London Luton Airport Expansion

Planning Inspectorate Scheme Ref: TR020001

**8.41 Surface Access Noise Modelling Additional
Information (Tracked Change Version)**

Application Document Ref: TR020001/APP/8.41

Drawing Title Figure 1  
 Change in 2043 Do-Something - Do-Minimum Daytime LAeq,16h Surface Access Noise Contours

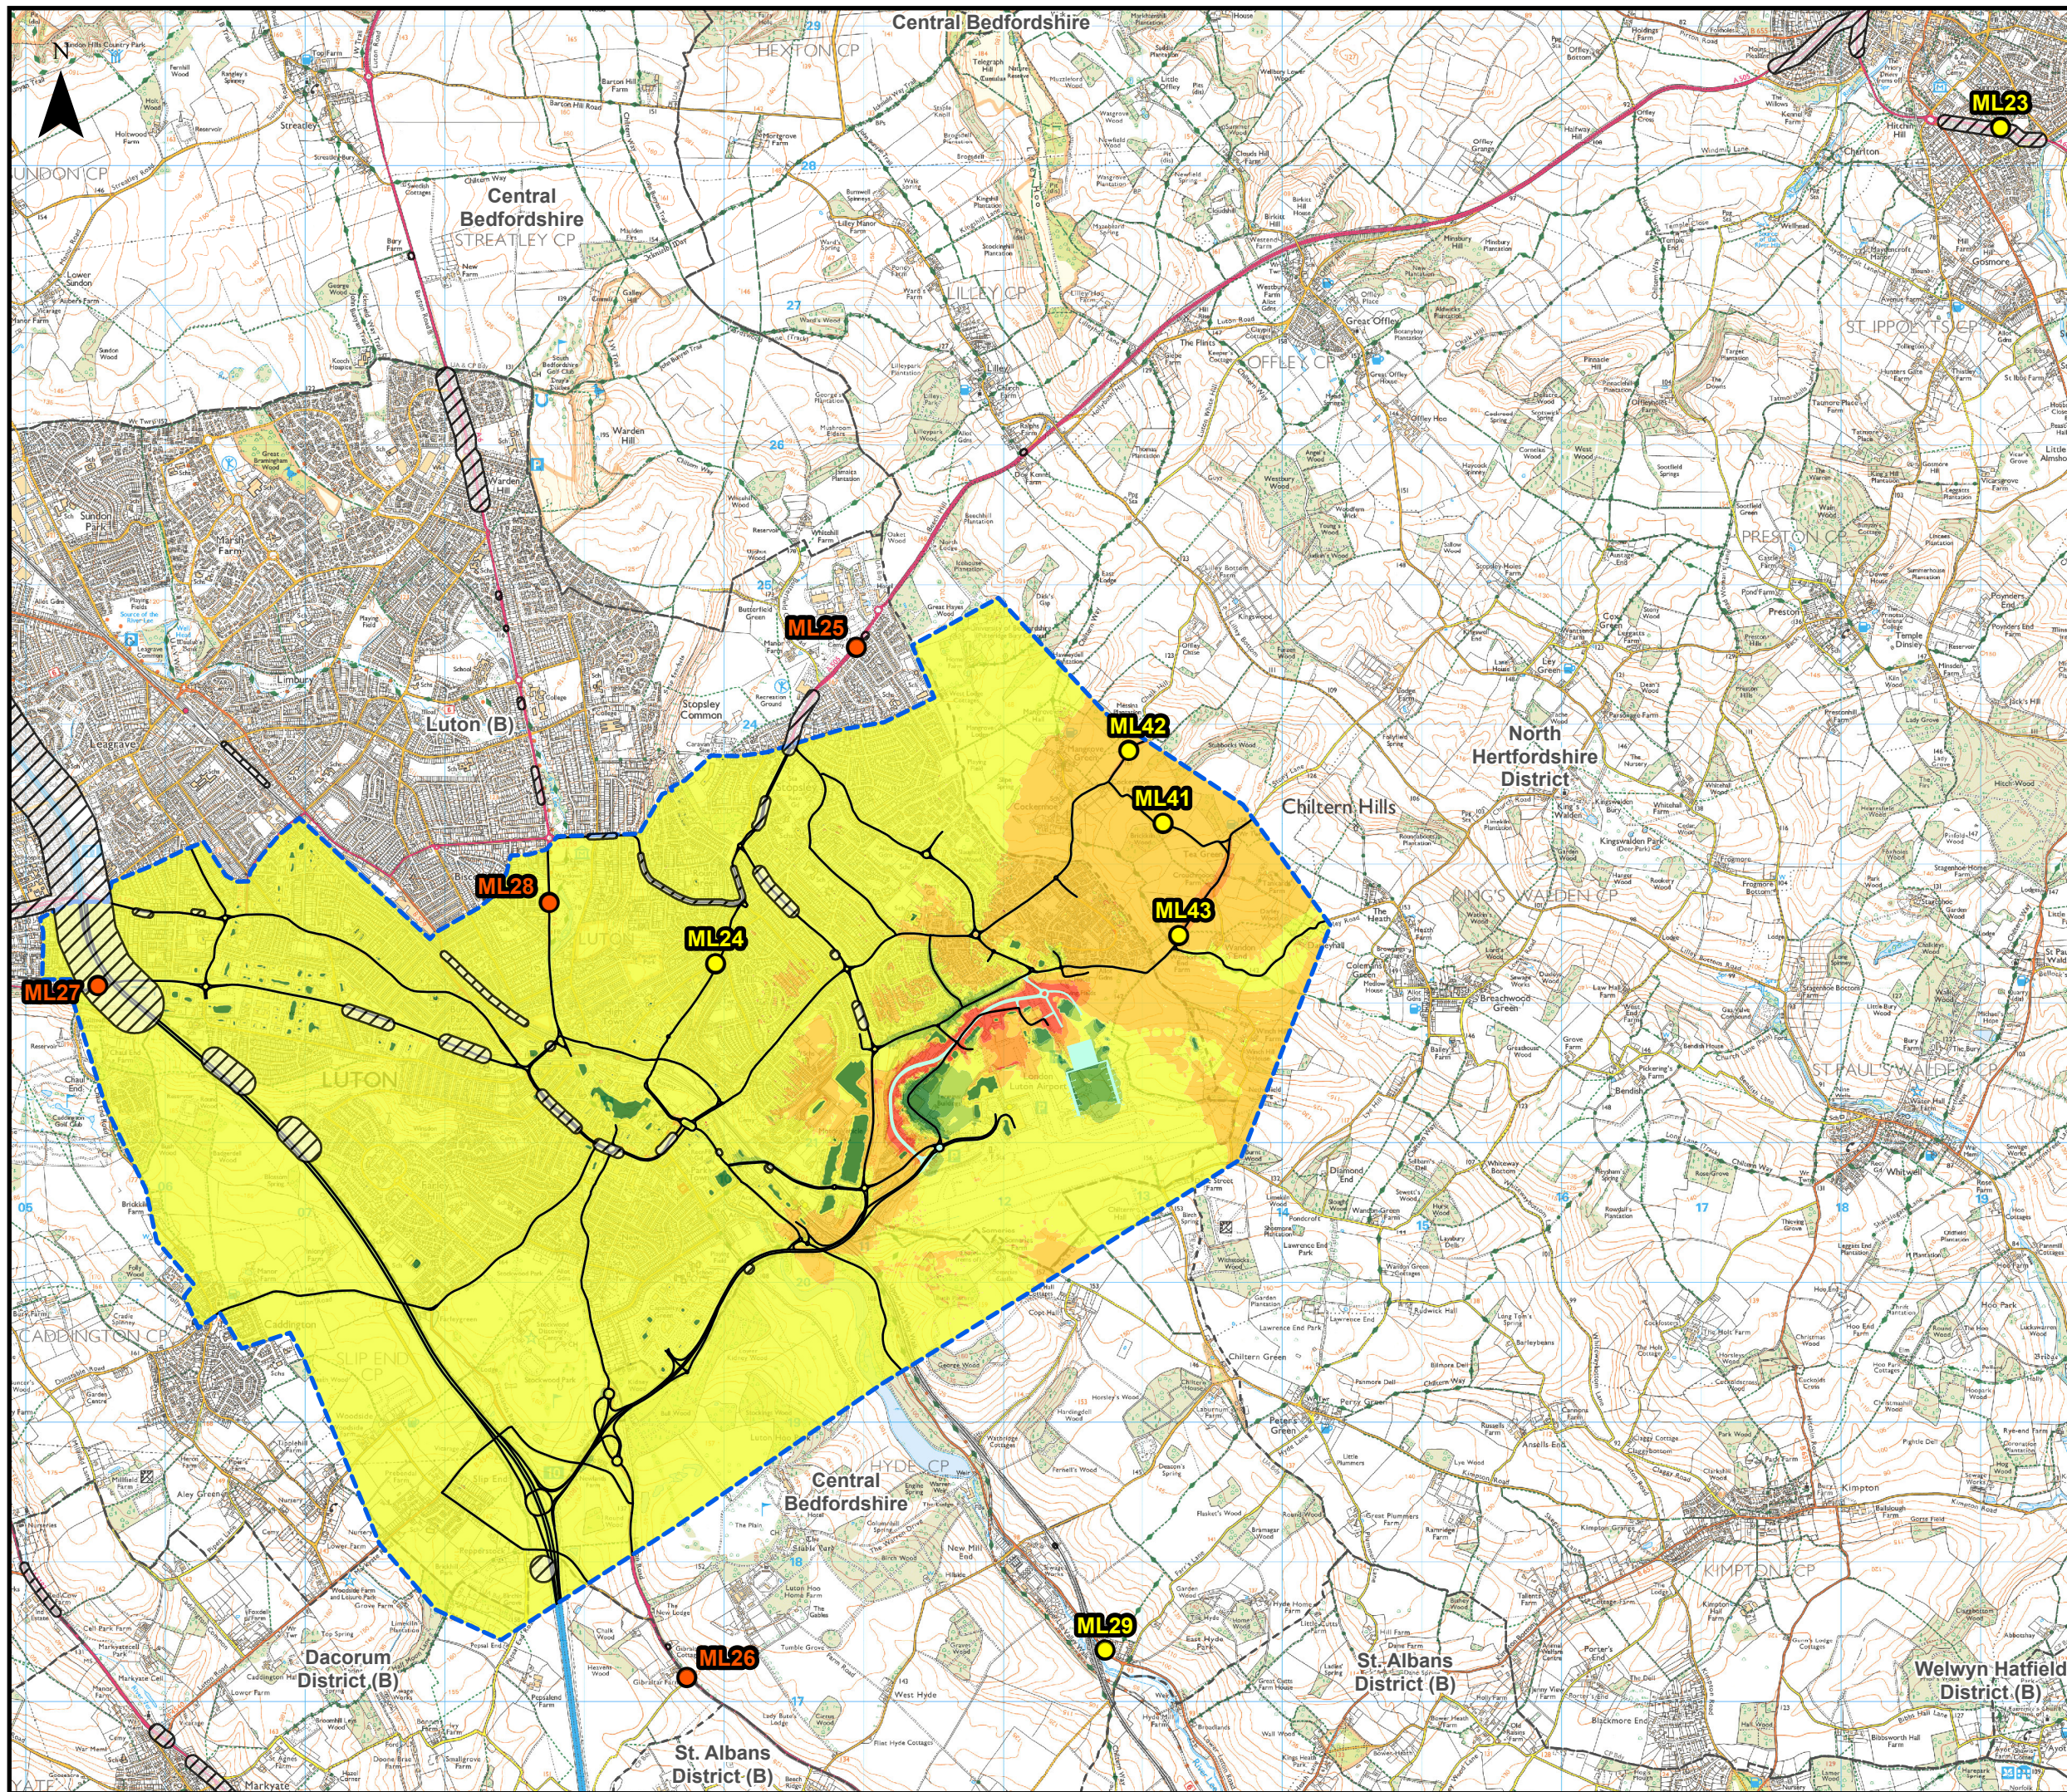
- 4.2.4 It is noted by the HAs that at four of these 11 locations (ML25-28) the L_{Aeq,16h} derived from the measured sound levels differs by more than 3 dB from the L_{Aeq,16h} derived from the road traffic noise model.

5.1.1 Following submission of this paper at Deadline 2, further technical discussions were held between the Applicant and the HAs and their noise consultant. In these sessions, the four monitoring locations that had previously been queried due to discrepancies of greater than 3 dB (ML25-28) were discussed in detail, including a review of the locations using Google Streetview.

5.1.4 Figure 1 and Figure 2 within this document have been updated with the corrected survey locations (this has only affected ML25-28).

4.2.10 Figure 1 and Figure 2 of this document show the monitoring locations overlaid on the surface access noise change contours for 2043. These figures show that the monitoring locations in question are either in areas expected to experience a negligible change in road traffic noise or outside of the surface access study area entirely². Given that localised corrections to the model would be applicable to both the Do-Minimum and Do-Something scenarios, the only change would be to absolute levels reported in the vicinity of these locations. And as explained in Section 4.1 this would not alter the conclusions of the assessment.

5.1.3 Following this exercise, the spot check exercise was repeated with the corrected actual survey locations, and details of the road surfacing conditions were provided to the HAs in writing, as per Table 5.1. As a result, it was agreed between the Applicant and the HA’s noise consultant that the discrepancies are due to locations specific factors, and it was agreed that the surface access noise model is appropriate. This will be recorded in the next update of the Statements of Common Ground.
